SCOPING OPINION FROM THE SECRETARY OF STATE DATED AUGUST 2020

Proposed East Northants Resource Management Facility Western Extension

Case Reference: WS010005

August 2020

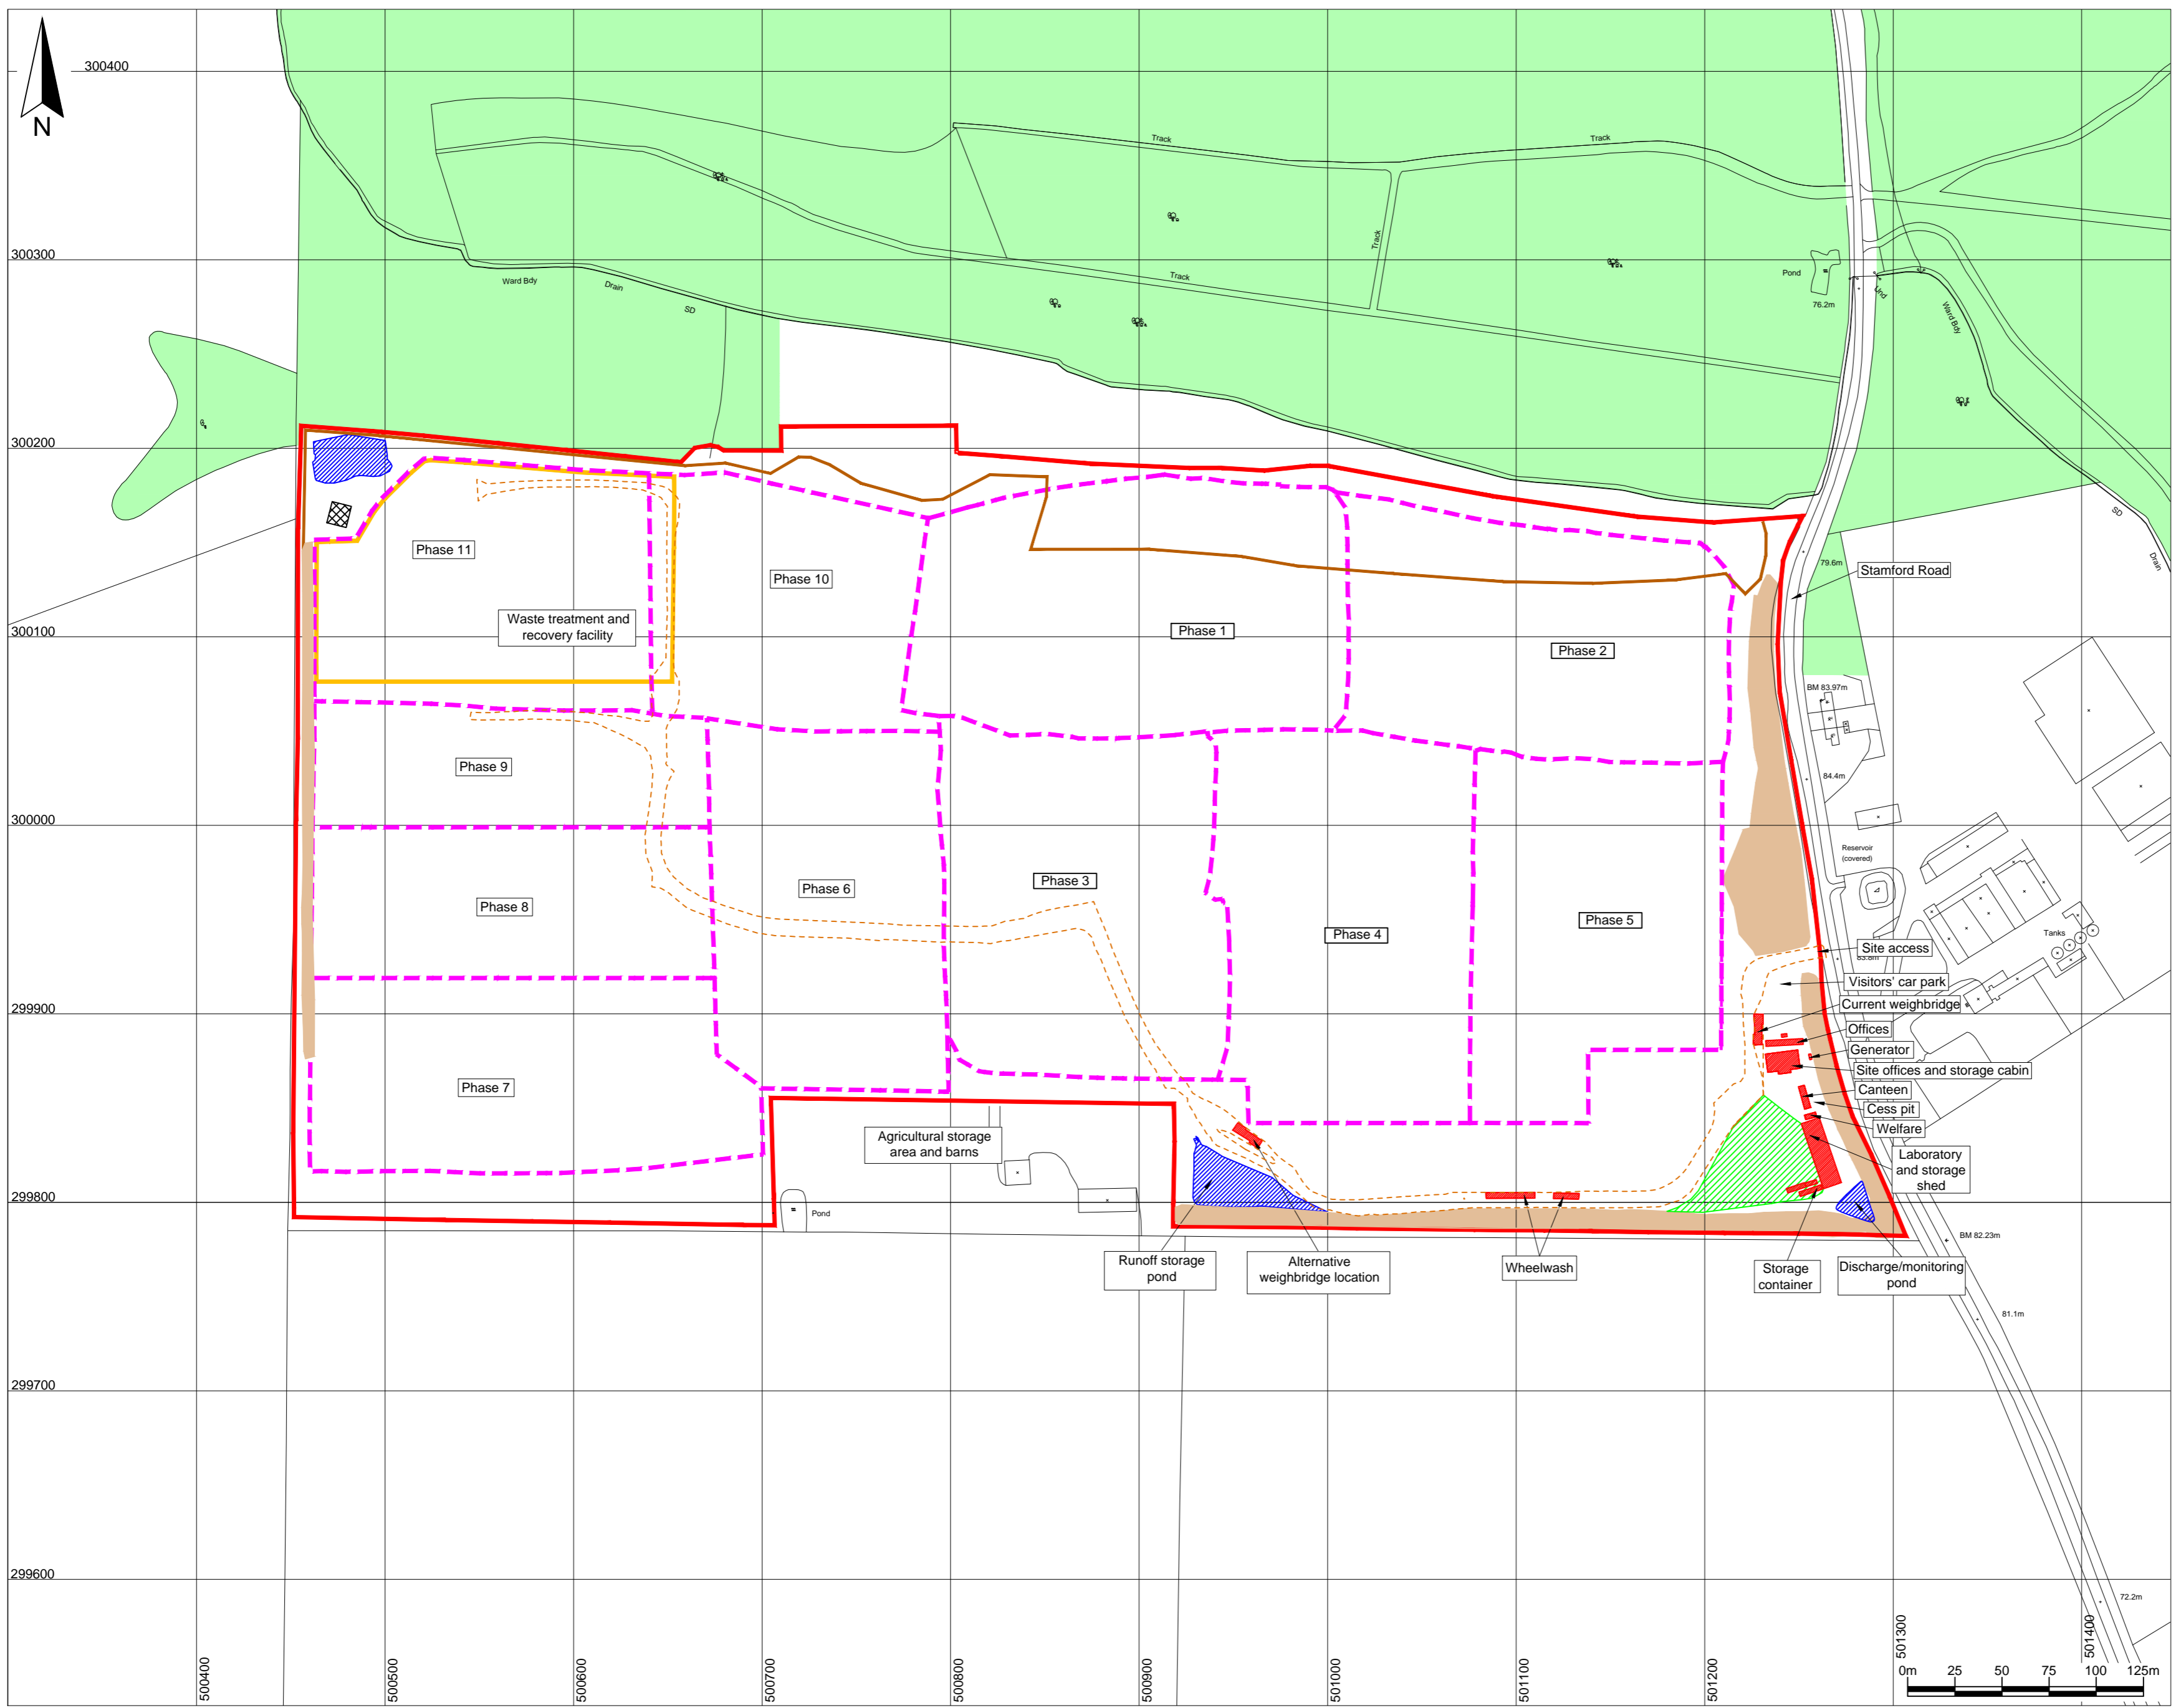
4.2.5	Paragraph 4.3.3 and Figure 2	Ancient woodland, Plantations on Ancient Woodland Sites (PAWS) and veteran trees	<p>The ES should include an assessment of effects on woodland, PAWS and veteran trees, where likely significant effects could occur. The Applicant is directed to the standing advice of the Forestry Commission and Natural England, as linked within their consultation responses at Appendix 2 to this Opinion. The ES should consider potential effects such as root damage, water availability to woodlands, potential contamination of groundwater, and effects on sensitive species within the woodlands. Appropriate cross-referencing to assessments within other relevant aspect chapters, such as the Water Resources and Soil Resources and Agricultural Land Classification, should be included.</p>

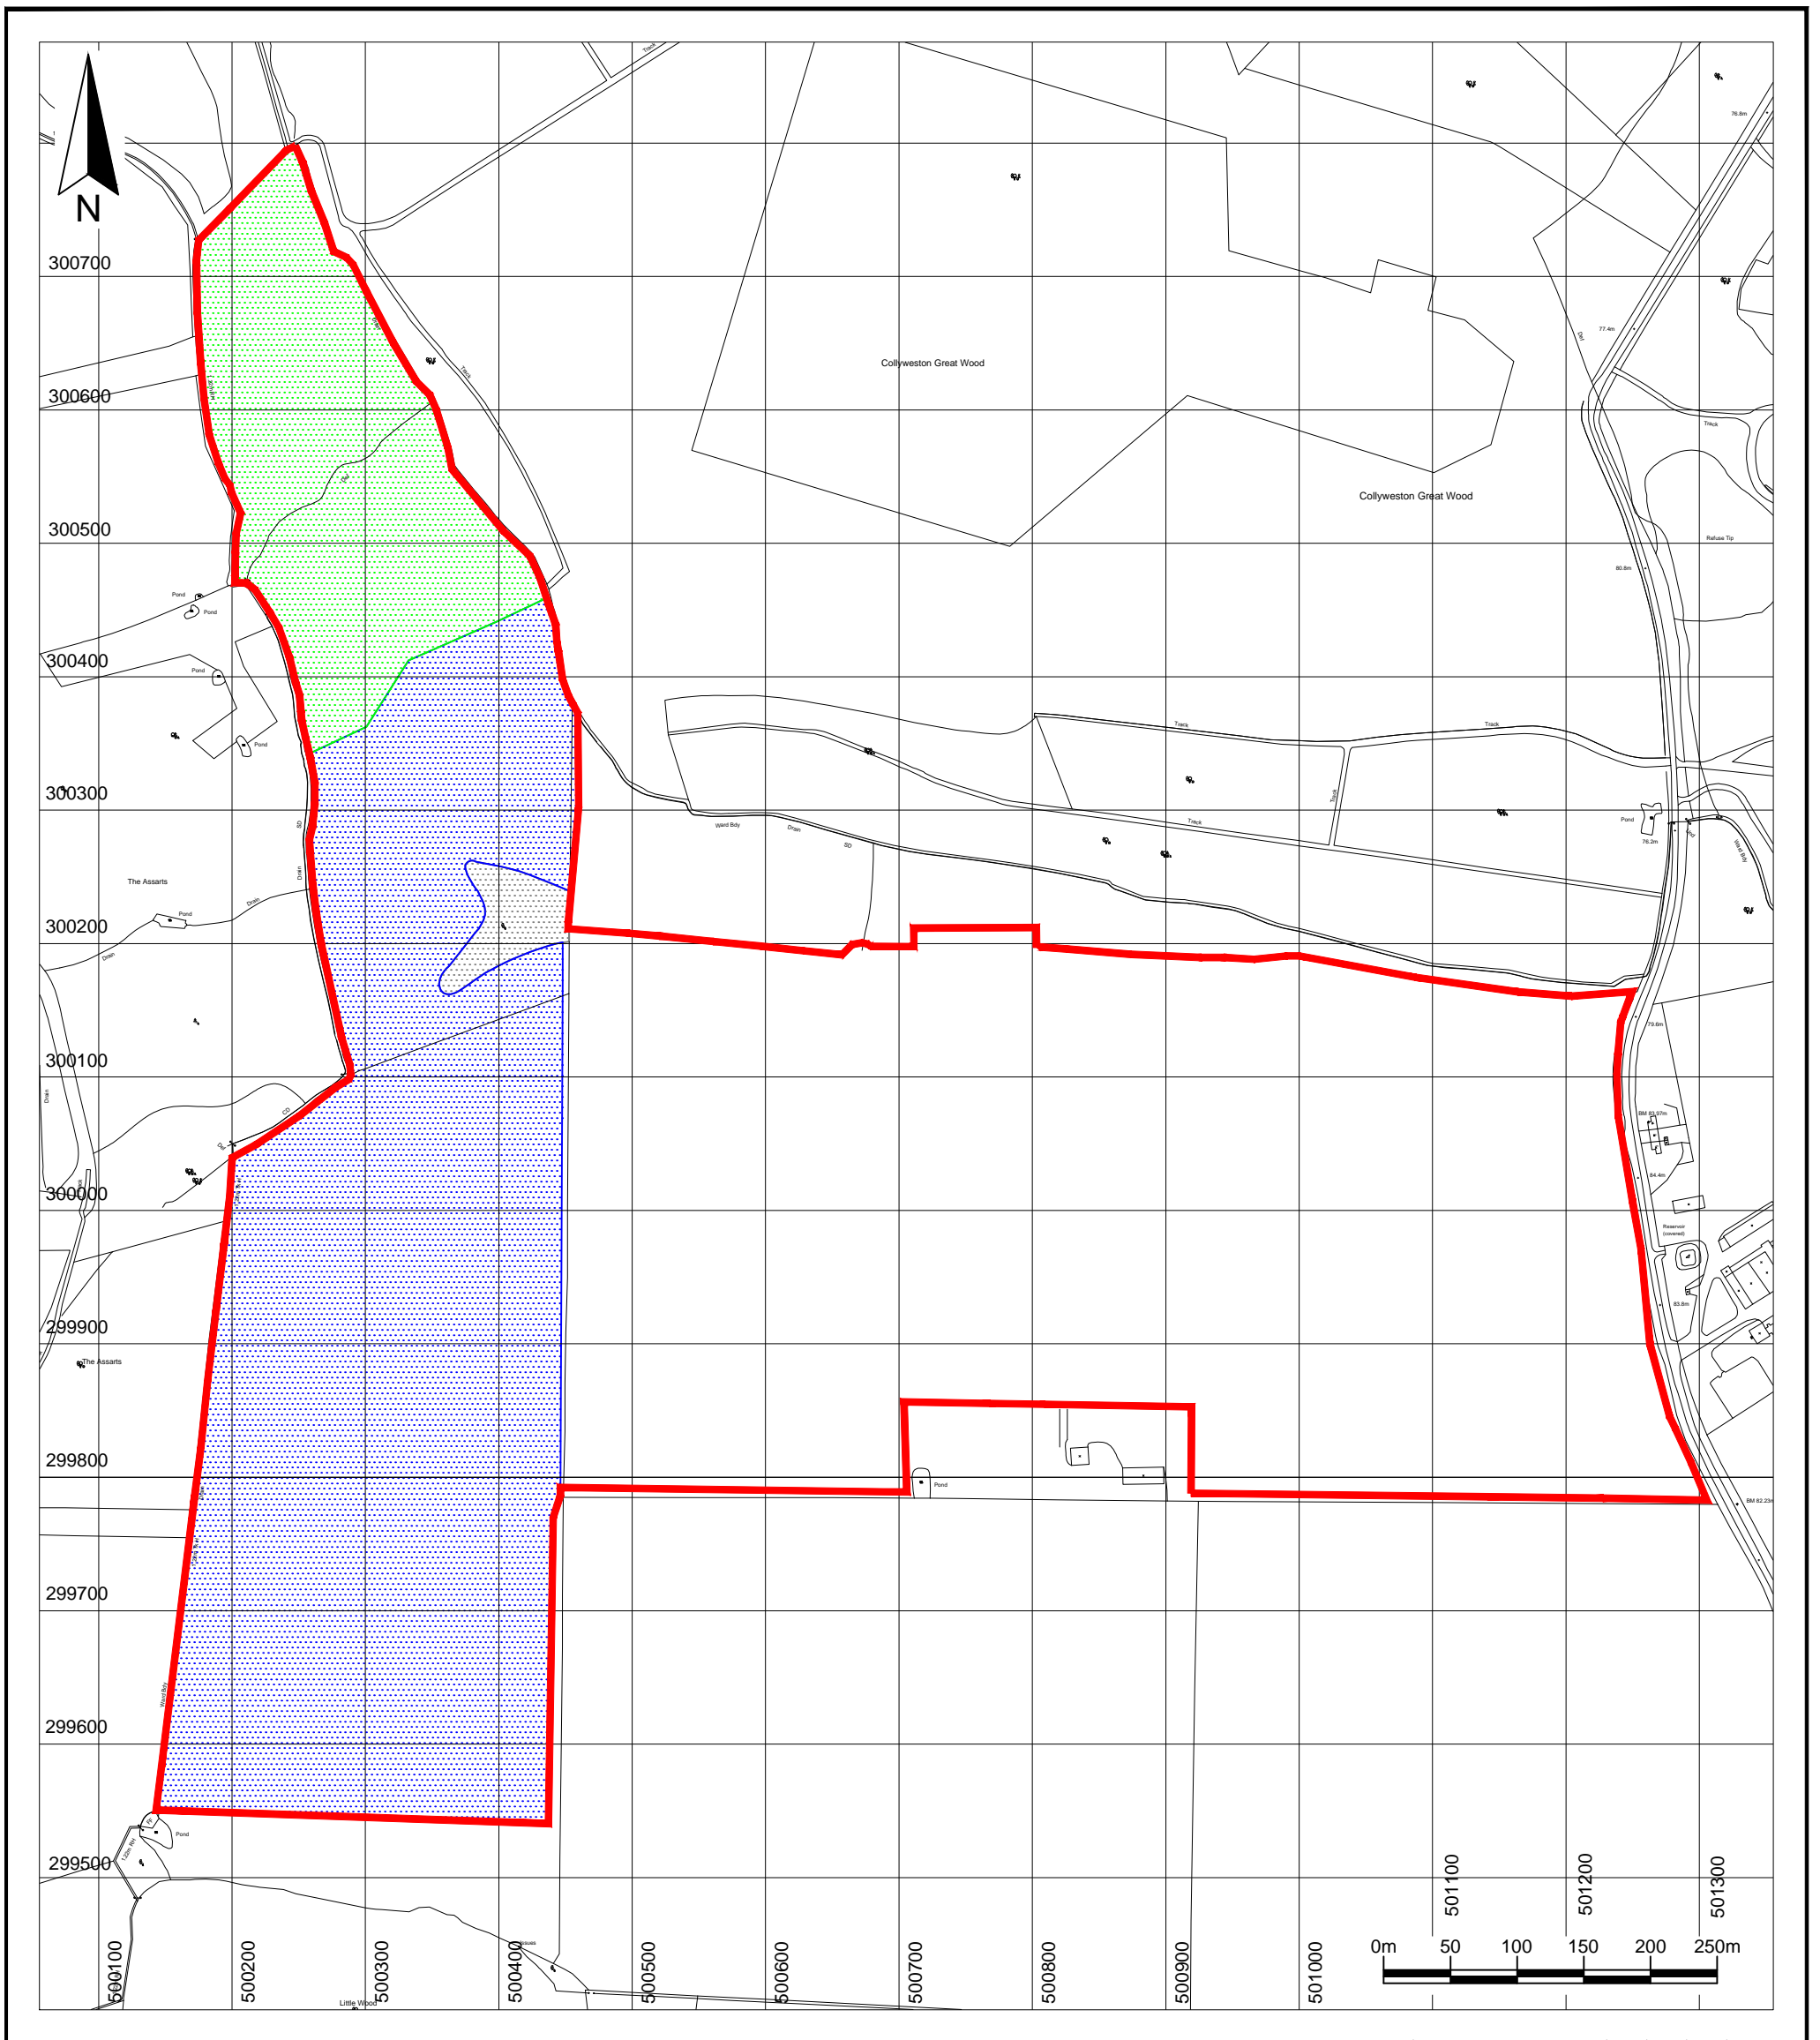
4.3.3	Paragraph 4.4.2, Figure 7	Representative viewpoints and Zone of Theoretical Visibility (ZTV)	<p>The Scoping Report outlines discussions undertaken with NCC to agree representative viewpoint locations. These are illustrated in Figure 7 to the Scoping Report. The Inspectorate also notes that a ZTV has been prepared.</p> <p>The Inspectorate welcomes the discussion with the Local Authority in effort to agree the landscape and visual impact assessment viewpoints and their illustration. The Inspectorate considers that effort should also be made to agree the ZTV. The ES should include a figure showing the ZTV for the Proposed Development and include viewshed analysis; with all individual residential properties, Public Rights of Way (PRoW) and roads within the ZTV identified, named and recorded with the level of visual impact attributed.</p>
